S2.0

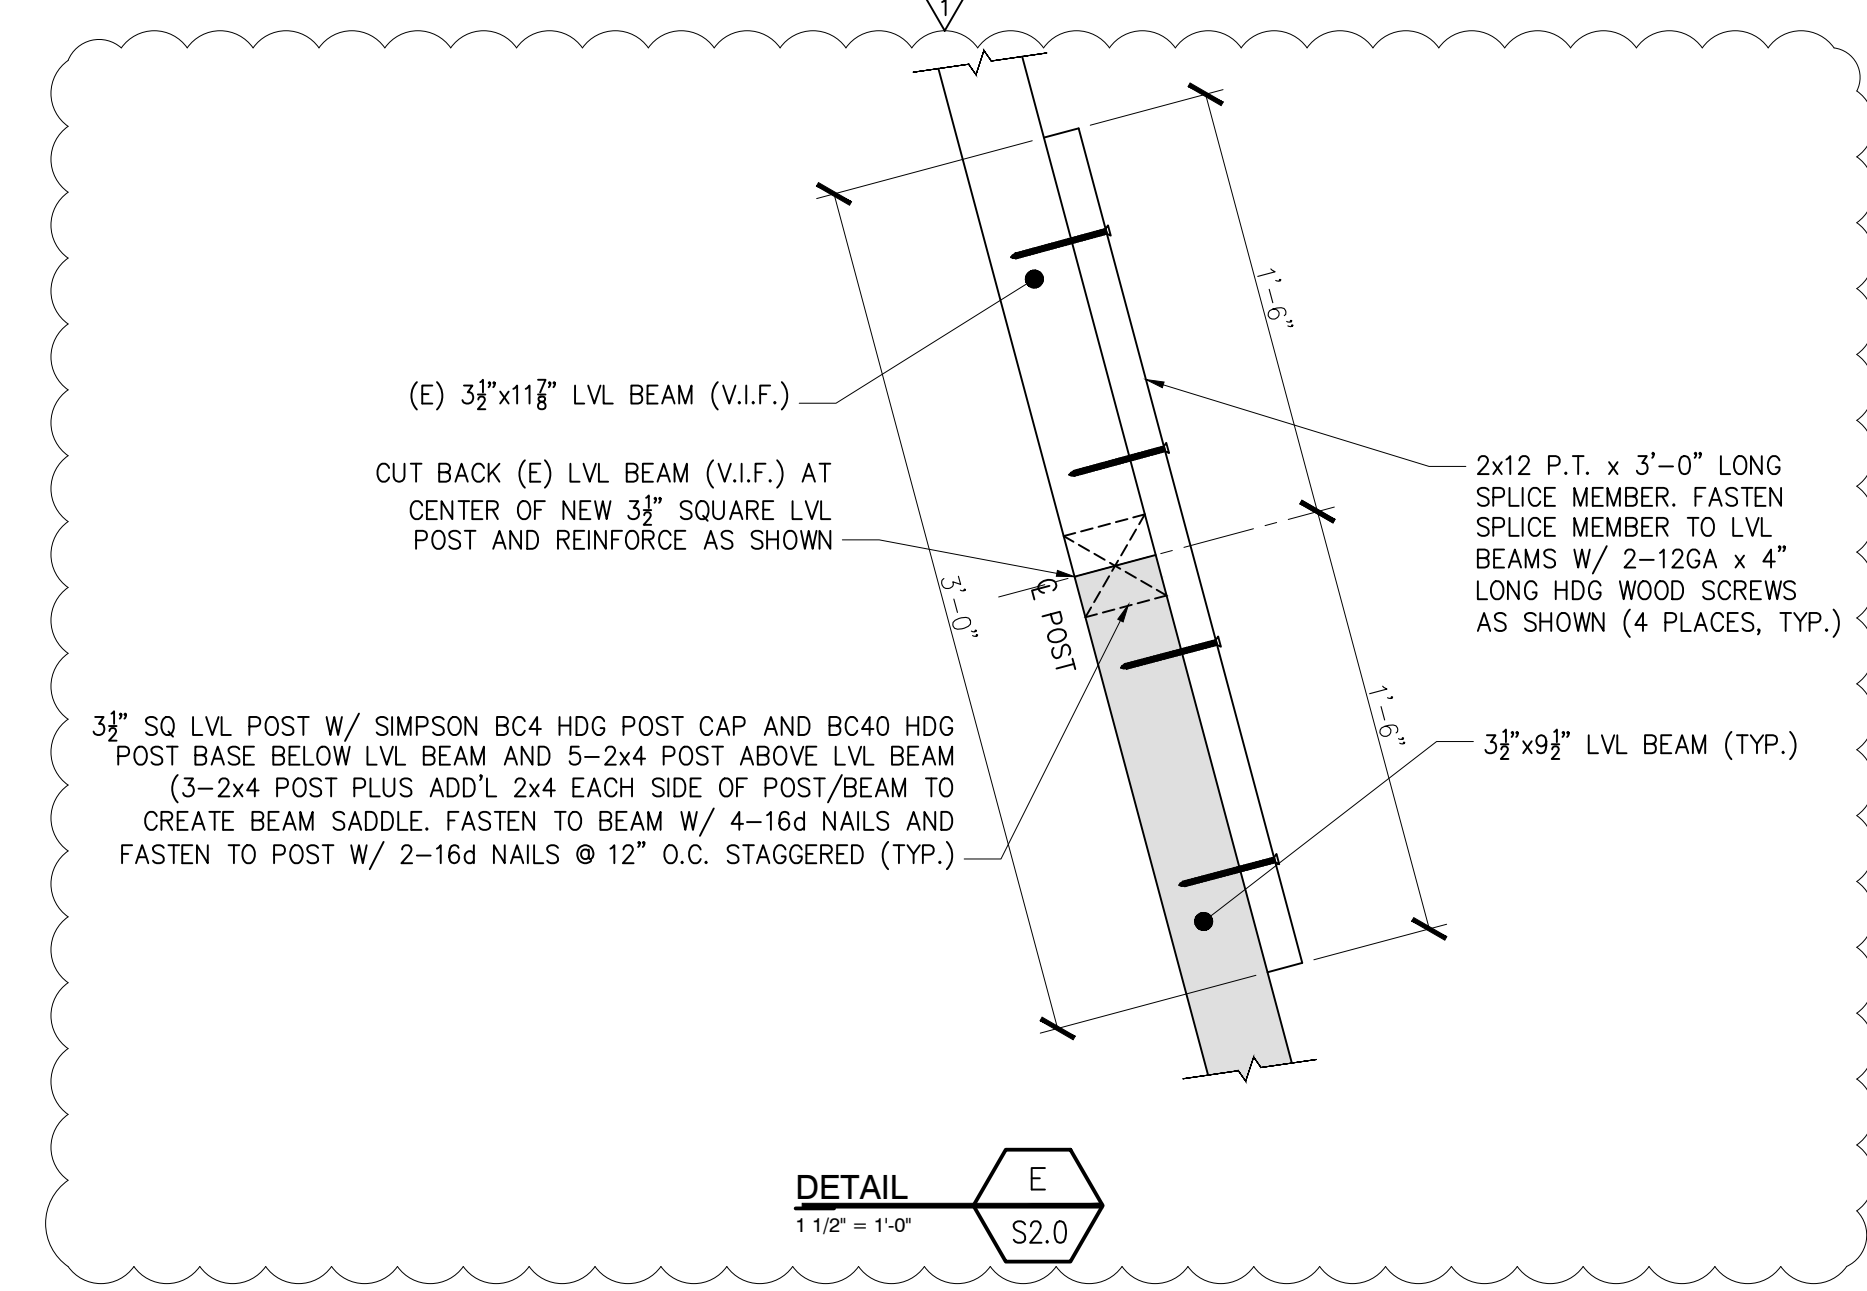
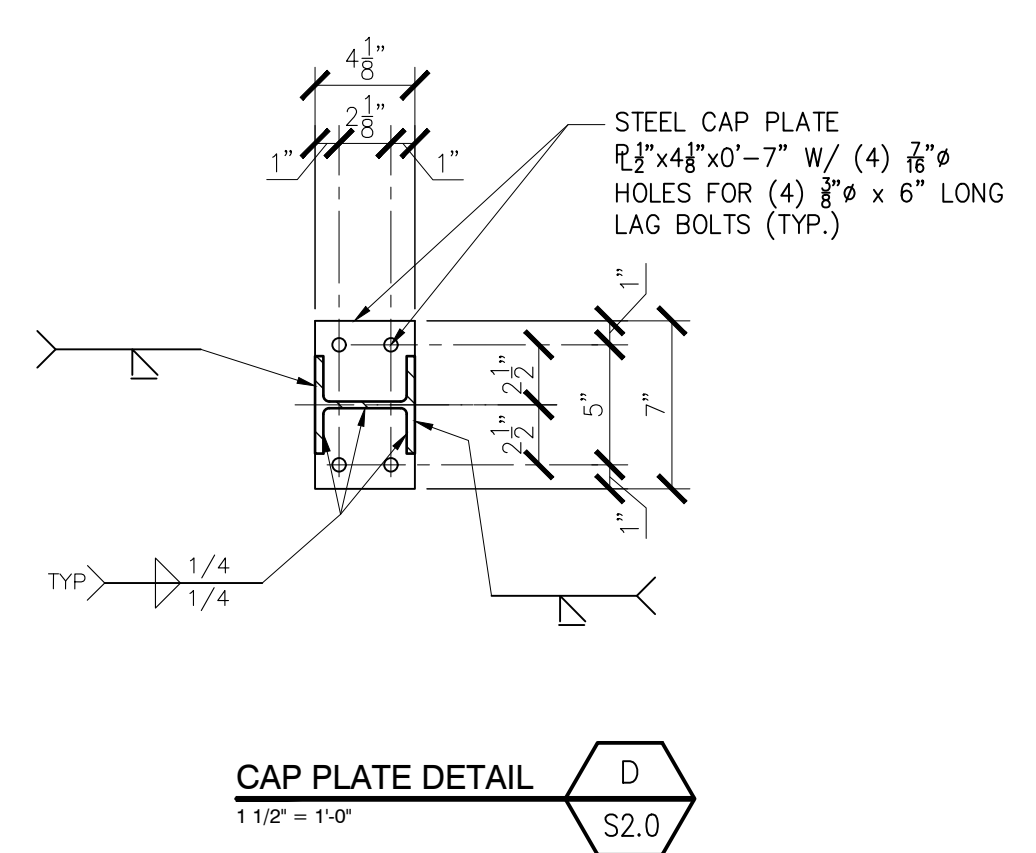
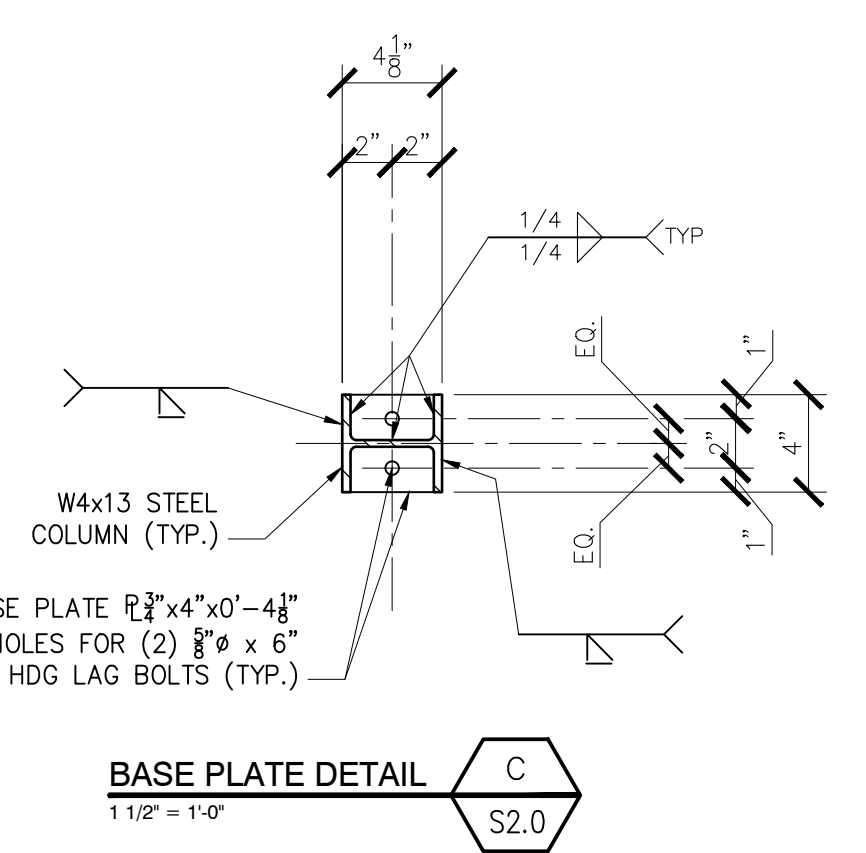
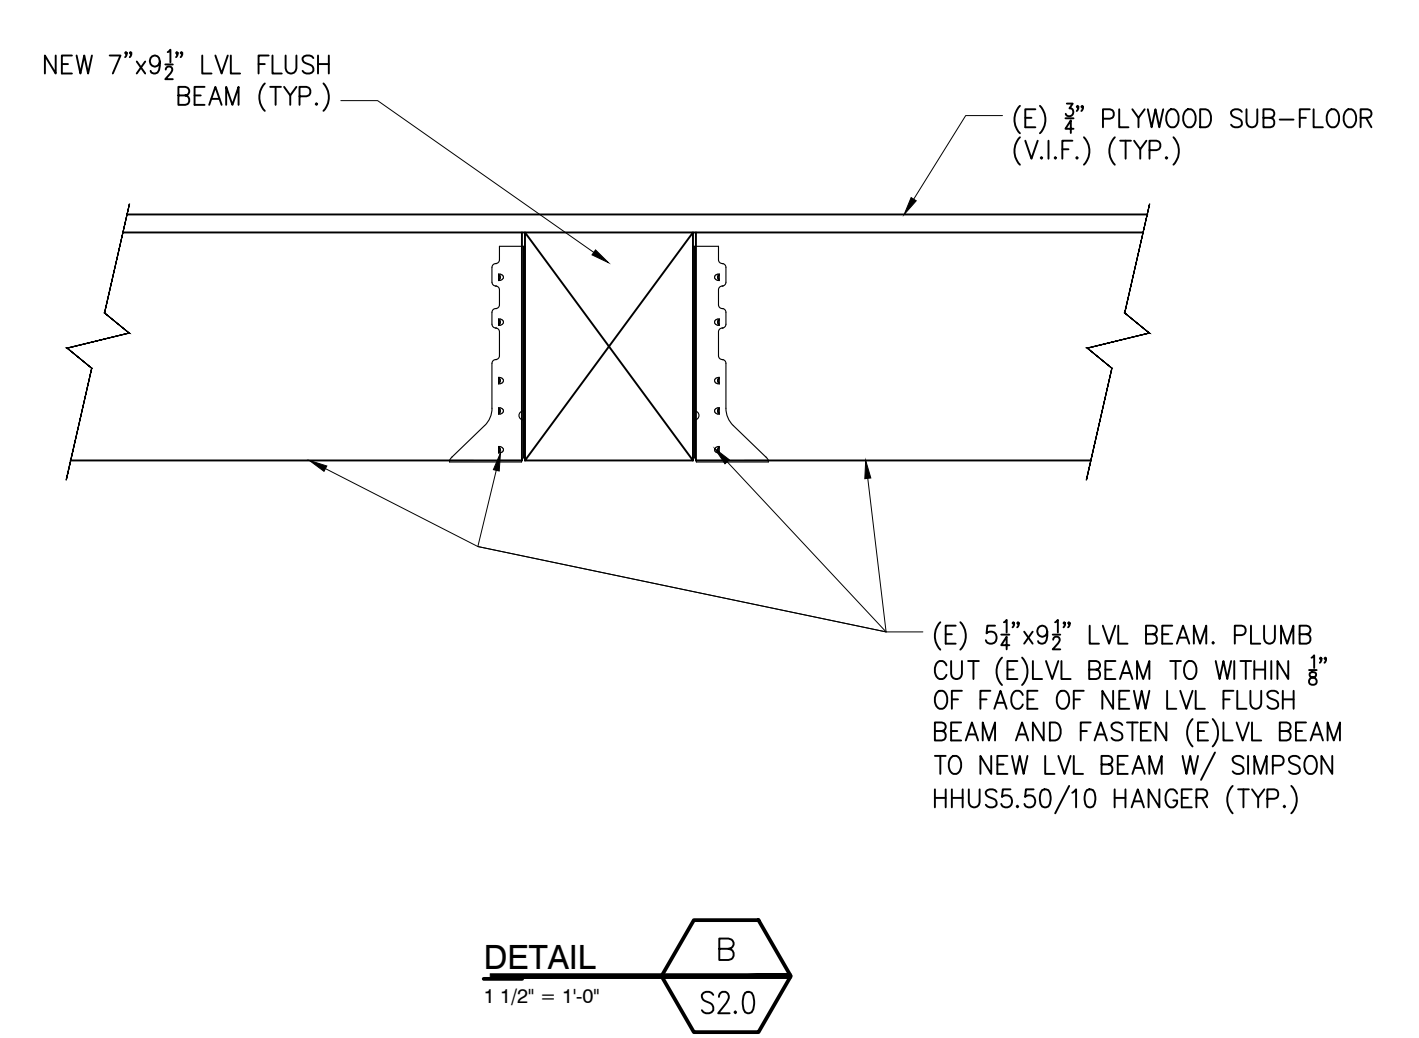
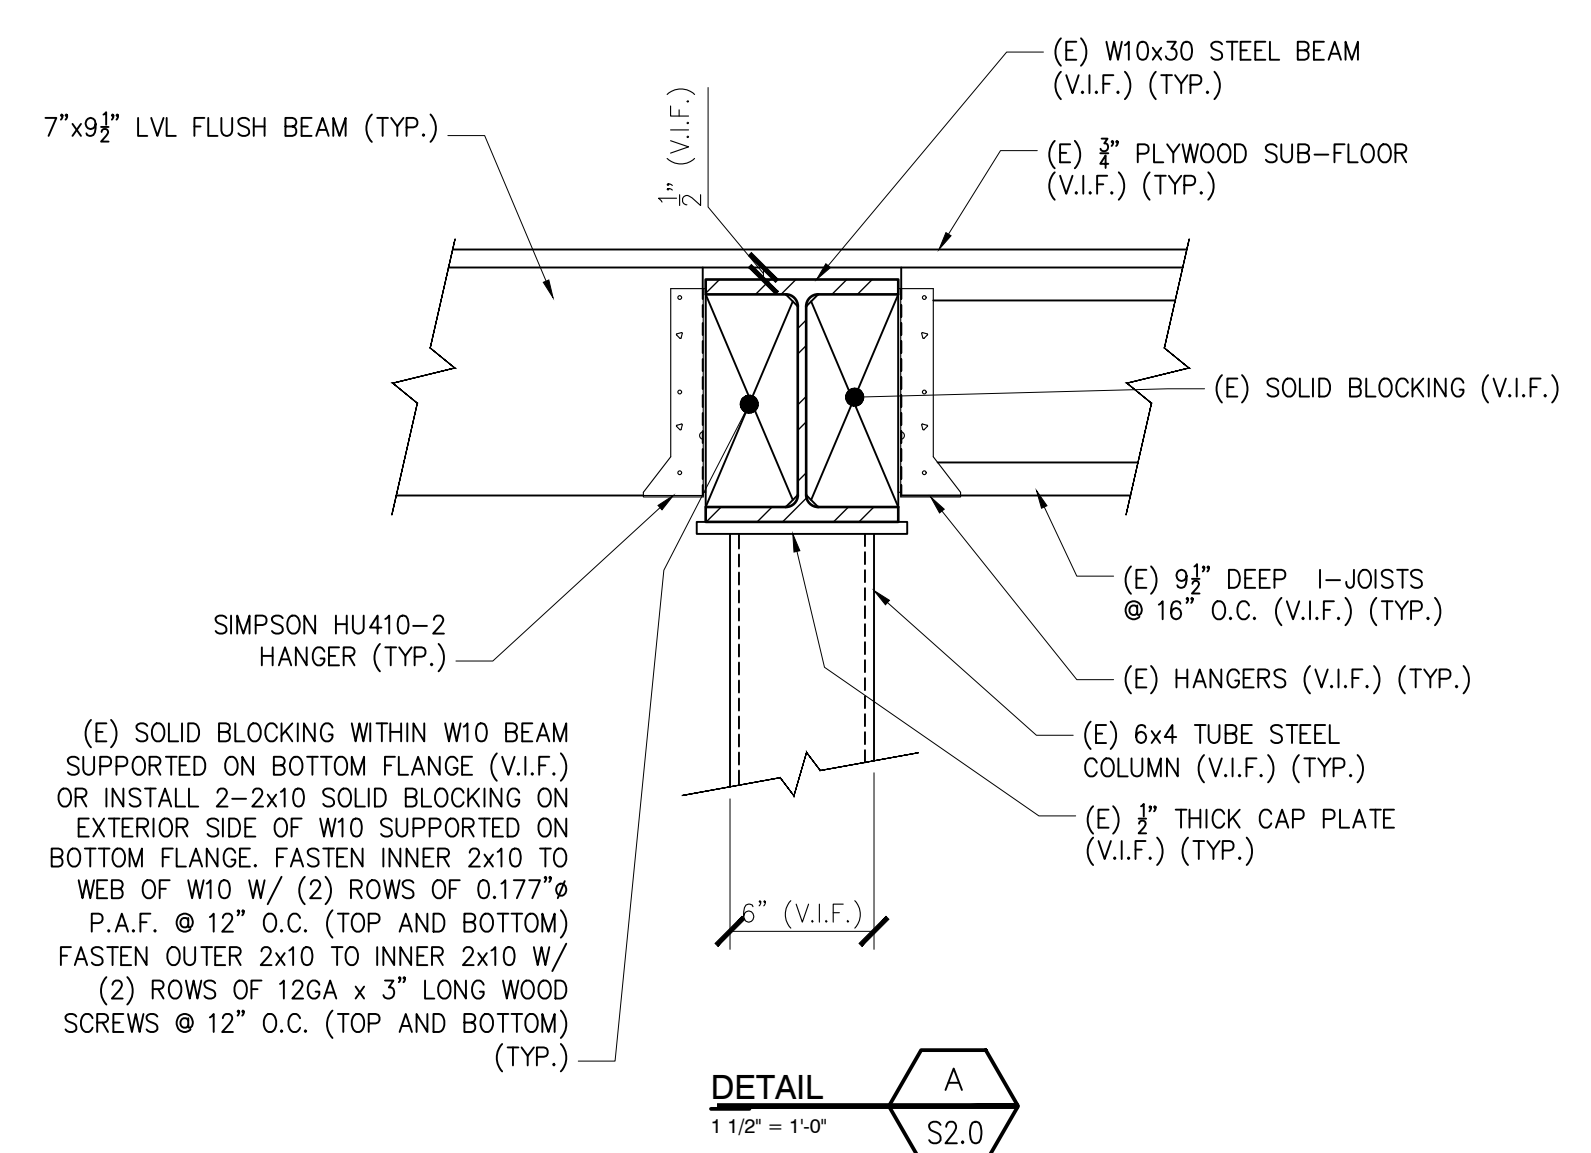
Please provide a section with more detailed framing sizes for girder spans at exterior bearing walls carrying 2 floors and a roof down to the first floor load bearing path per IRC Table R5020.5(1)

1 ADDITION FRAMING
4 1ST FLOOR - SEE REVISED STRUCTURAL DWGS FOR UPDATE POST 11.1.17

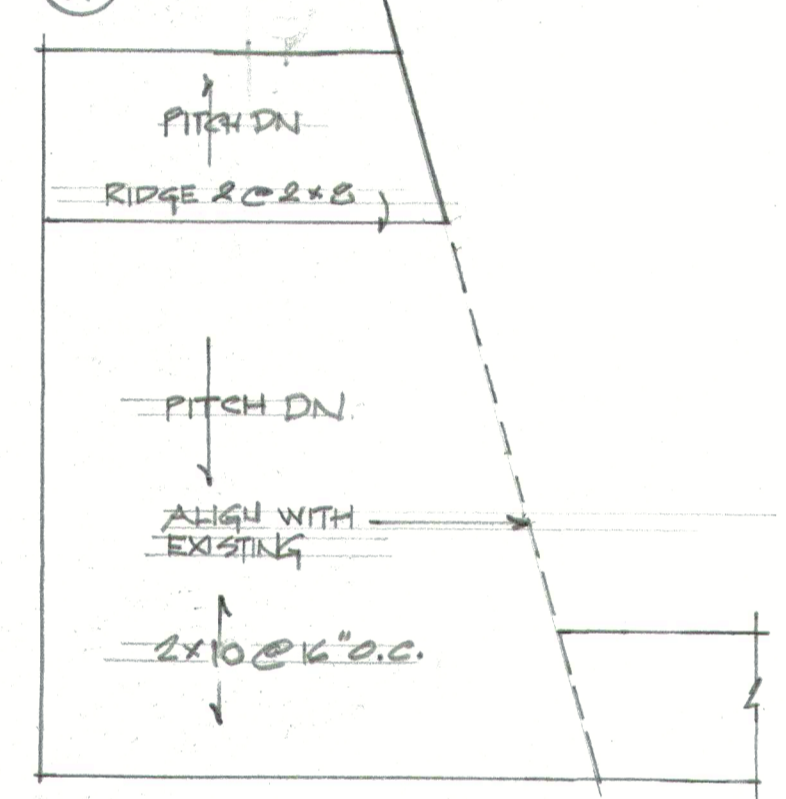
Please note tempered glazing
